| Application number: 2019/91327   |                                                                                  |
| What is the application for?:    | Reserved matters application pursuant to outline permission 2017/90207 for erect |
| Address of the site or building: | Thongsbridge Mills, Miry Lane, Thongsbridge, Holmfirth, HD9 7RW                  |

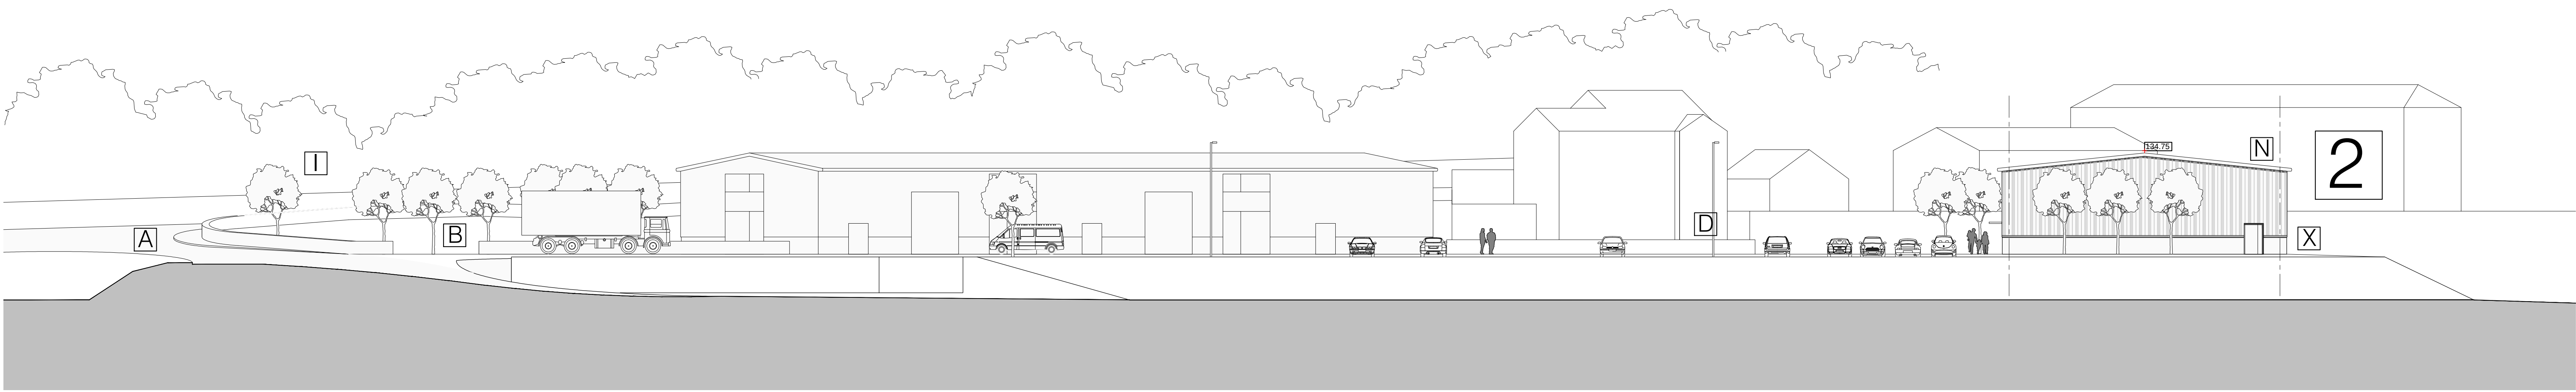
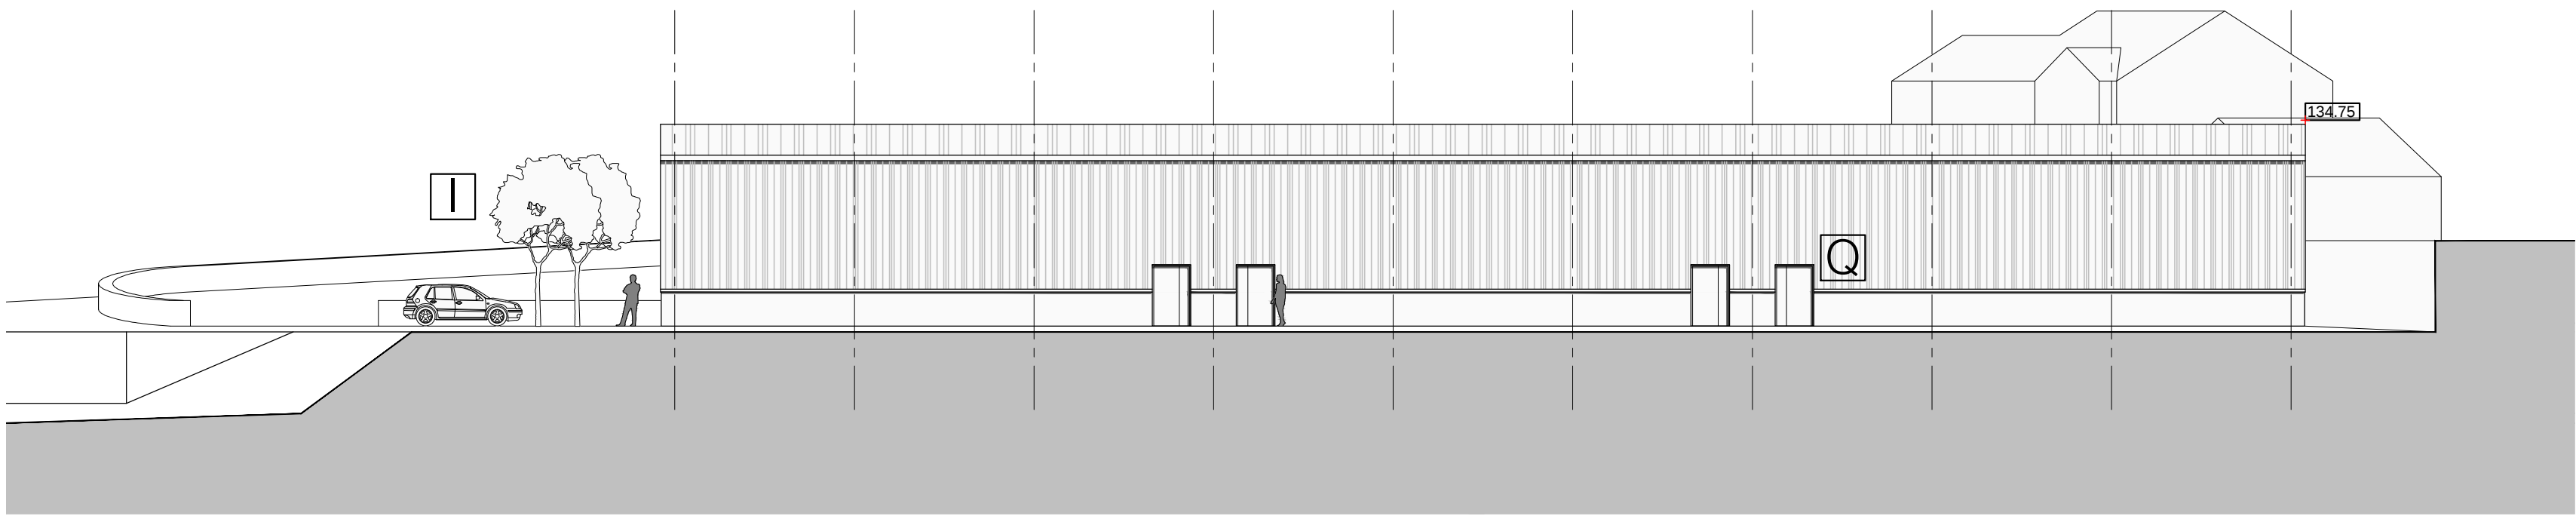
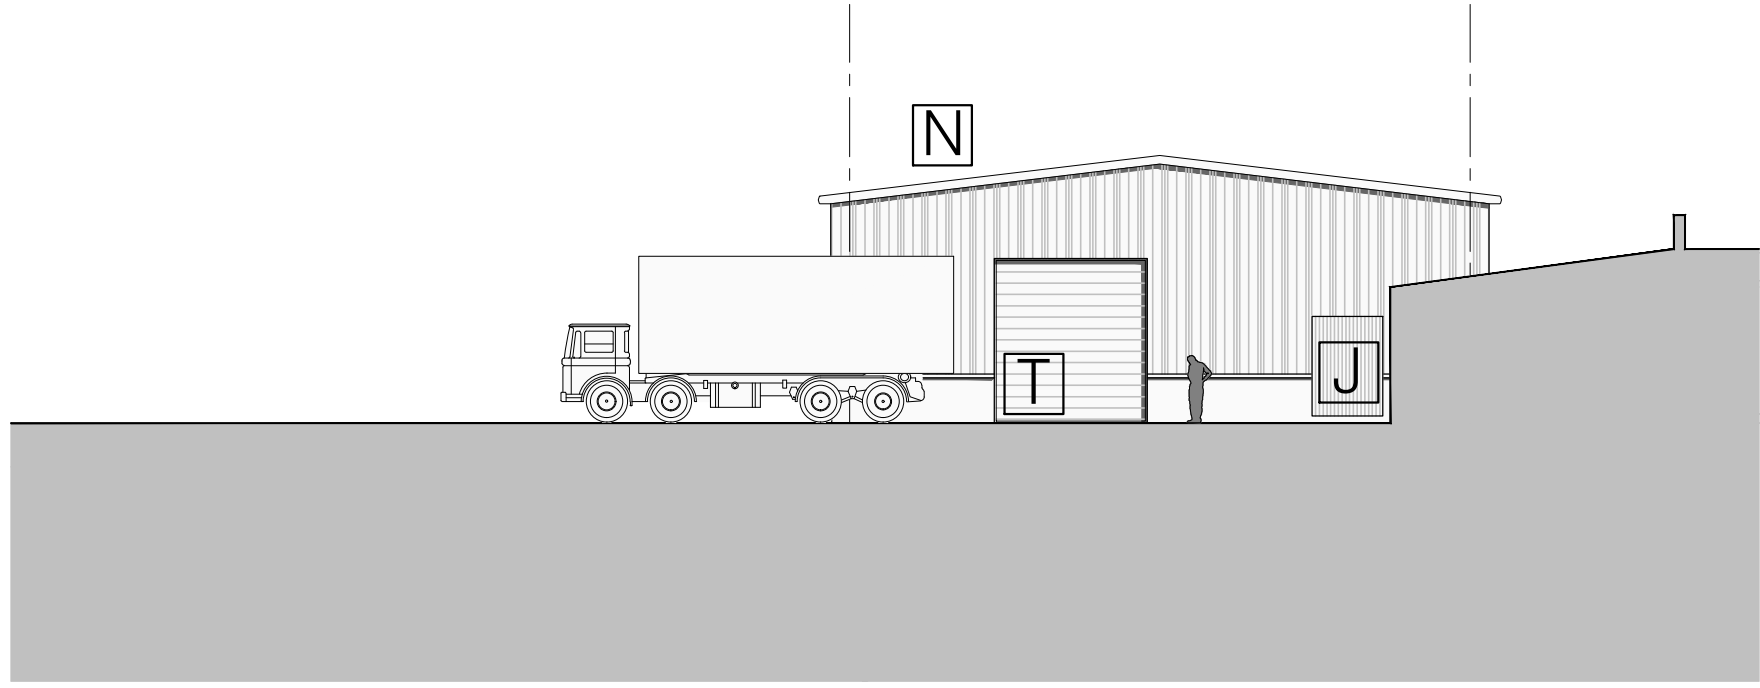
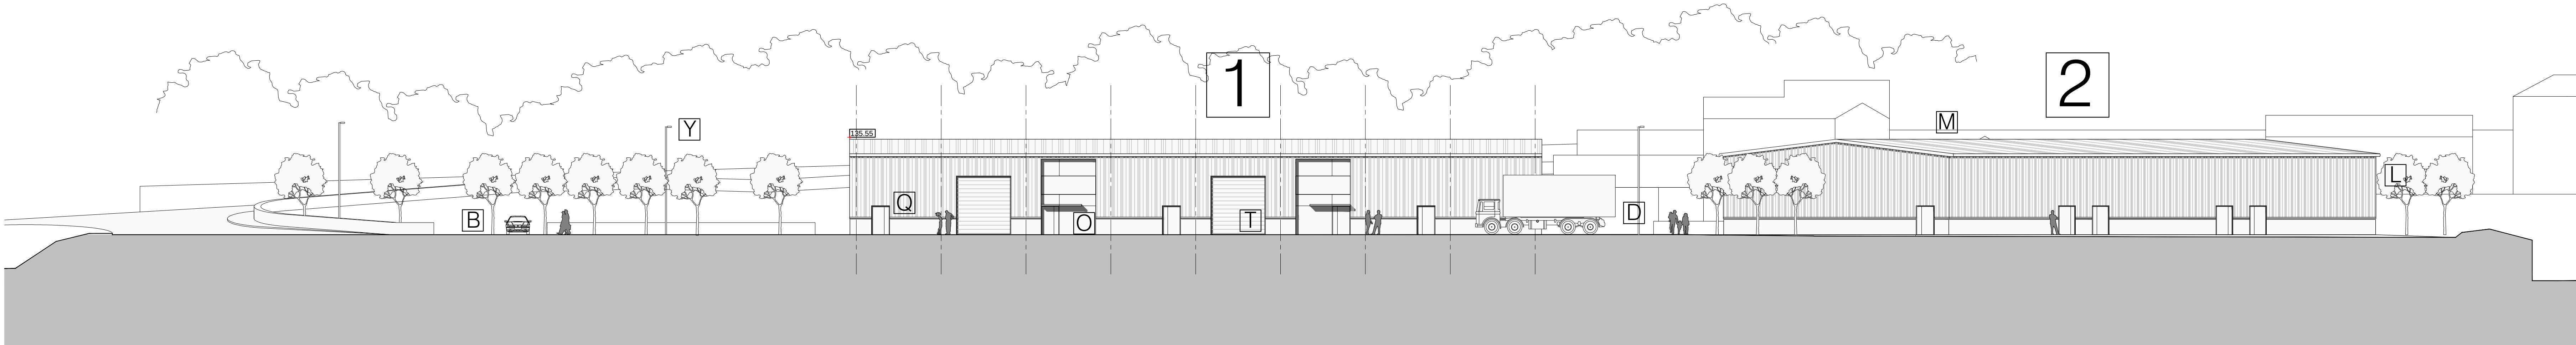
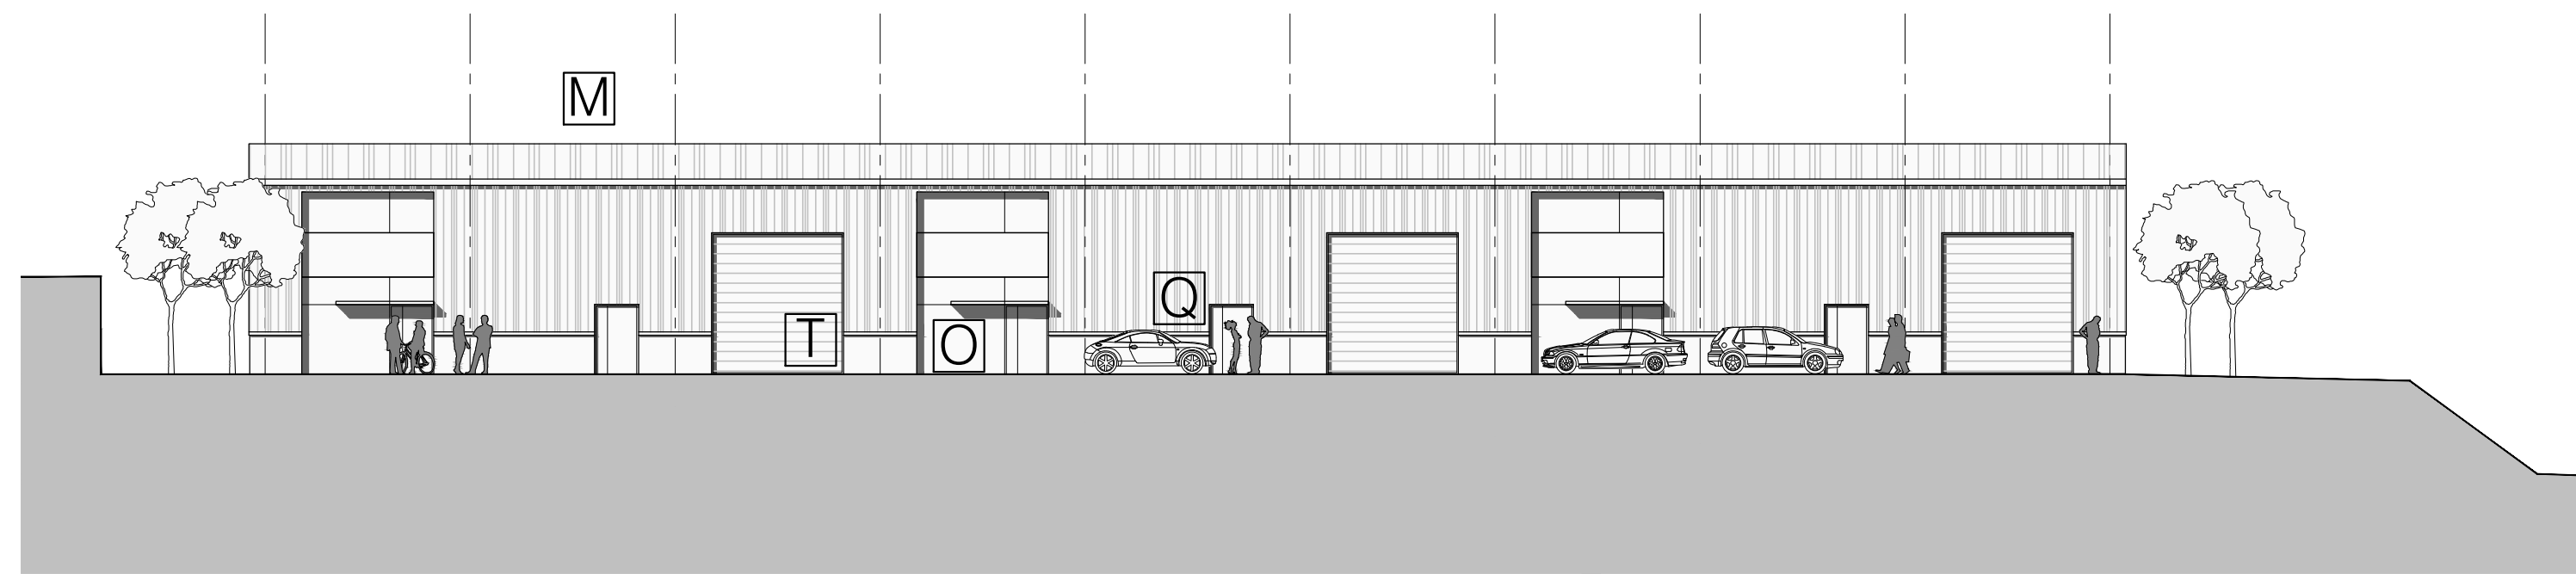
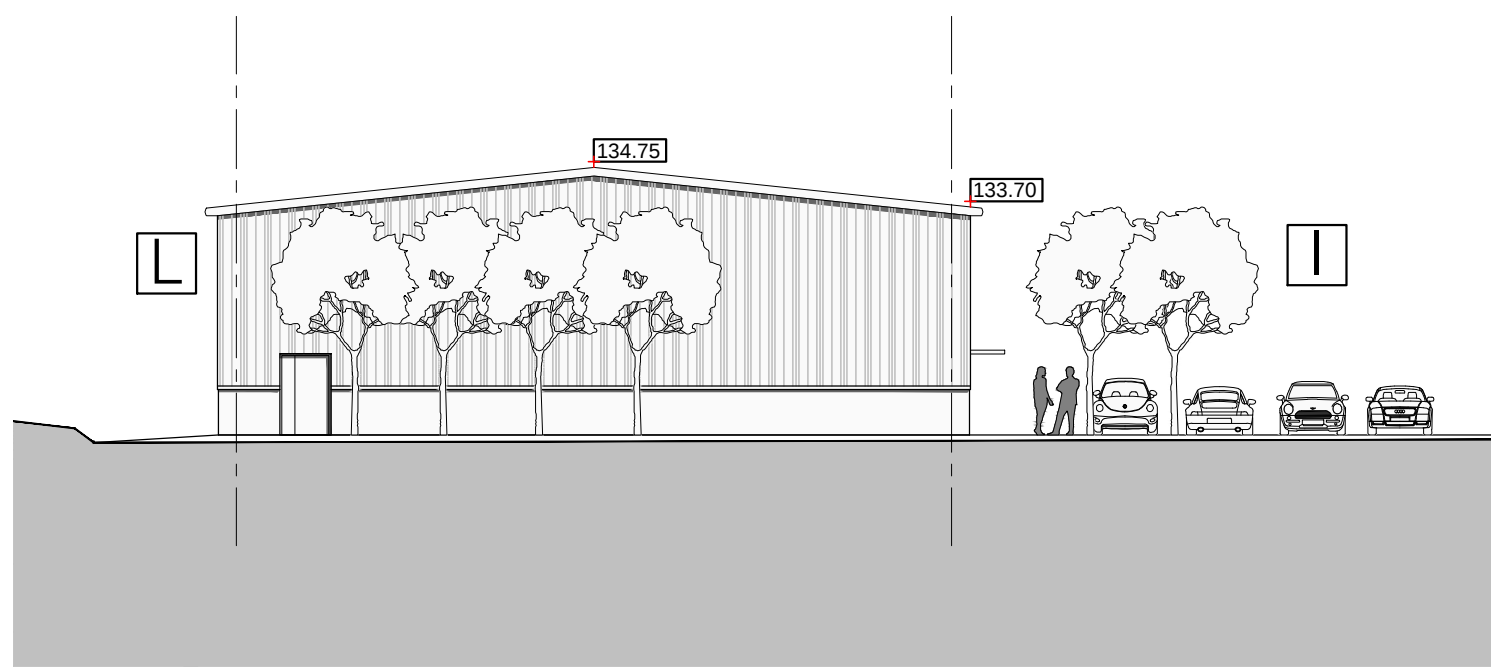
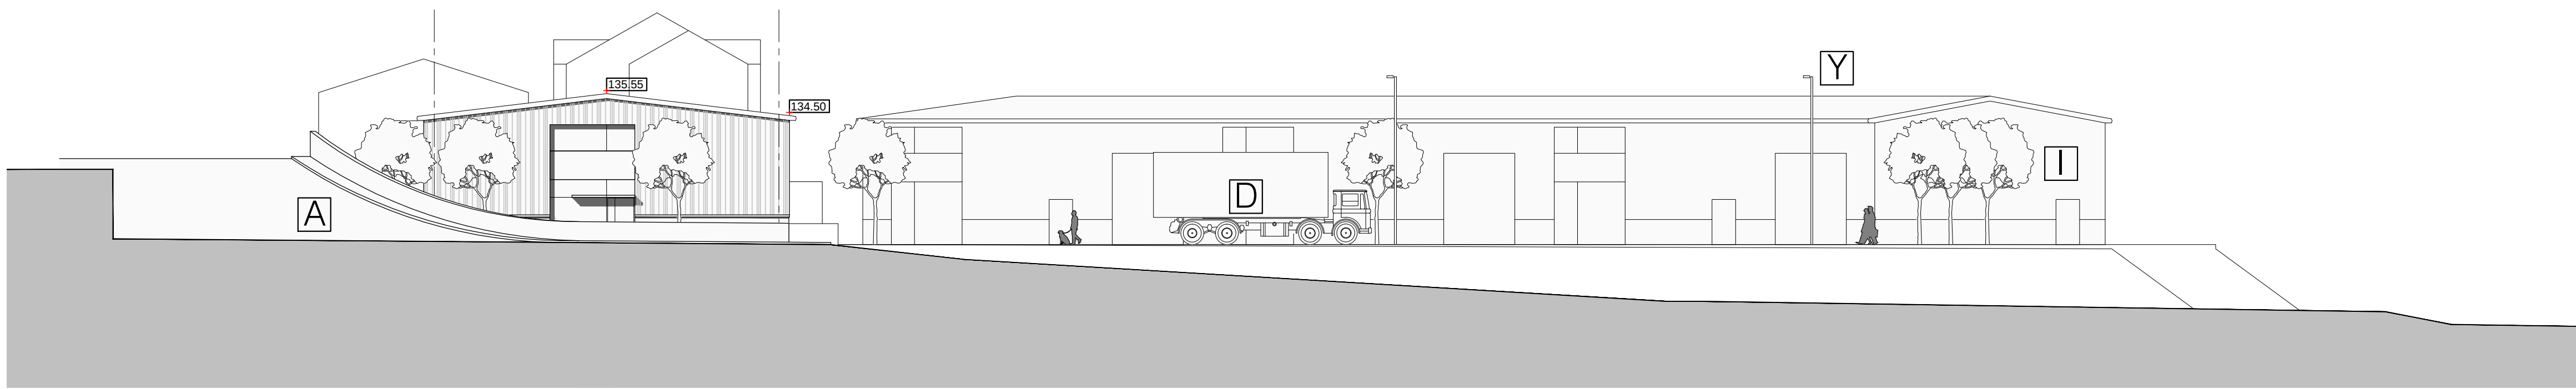
| <p>Objection to planning application 2019/91327 on the following grounds;</p> <p>Policy PLP24</p> <p>the form, scale, layout and details of all development respects and enhances the character of the townscape, heritage assets and landscape;<br/>they provide a high standard of amenity for future and neighboring occupiers; including maintaining appropriate distances between buildings and the creation of development-free buffer zones</p> <p>We would contend that the proposed development does none of the above. It does not, by way of form, scale, layout, appropriate distances between buildings,<br/>And most certainly does not respect the character of the townscape.<br/>is not a listed building, it dates back to 1890 and was the mill owners house.</p> <p>. We believe should be considered as a heritage asset and therefore the negative impact should be fully considered as part of this application.</p> <p>The submitted plans do not show our kitchen extension on the plans. Also, the site plan &amp; location plan are slightly misleading as reference is made to an electricity substation . The substation is in fact attached to the rear of .</p> <p>We attach a revised location plan indicating this</p> <p>The proposed development in its current form (in particular Unit 2), will have a serious and will have an , due to the very close proximity of the proposed building and the scale and height of the proposed building.</p> |

The is the main aspect of living accommodation. and look out directly onto the application site/proposal. The proposal will have an areas from early morning to afternoon. will therefore be seriously compromised for at least 6 months of the year.

To summarise, the proposal, in particular Unit 2, will have a considerable overbearing negative impact . This will seriously blight and have a huge negative impact .

We therefore respectfully request that Kirklees Planning give full consideration to our concerns regarding the current proposal. We would expect as a minimum that further thought is given to the layout and scale of the proposed development, so as to have considerably less impact on .
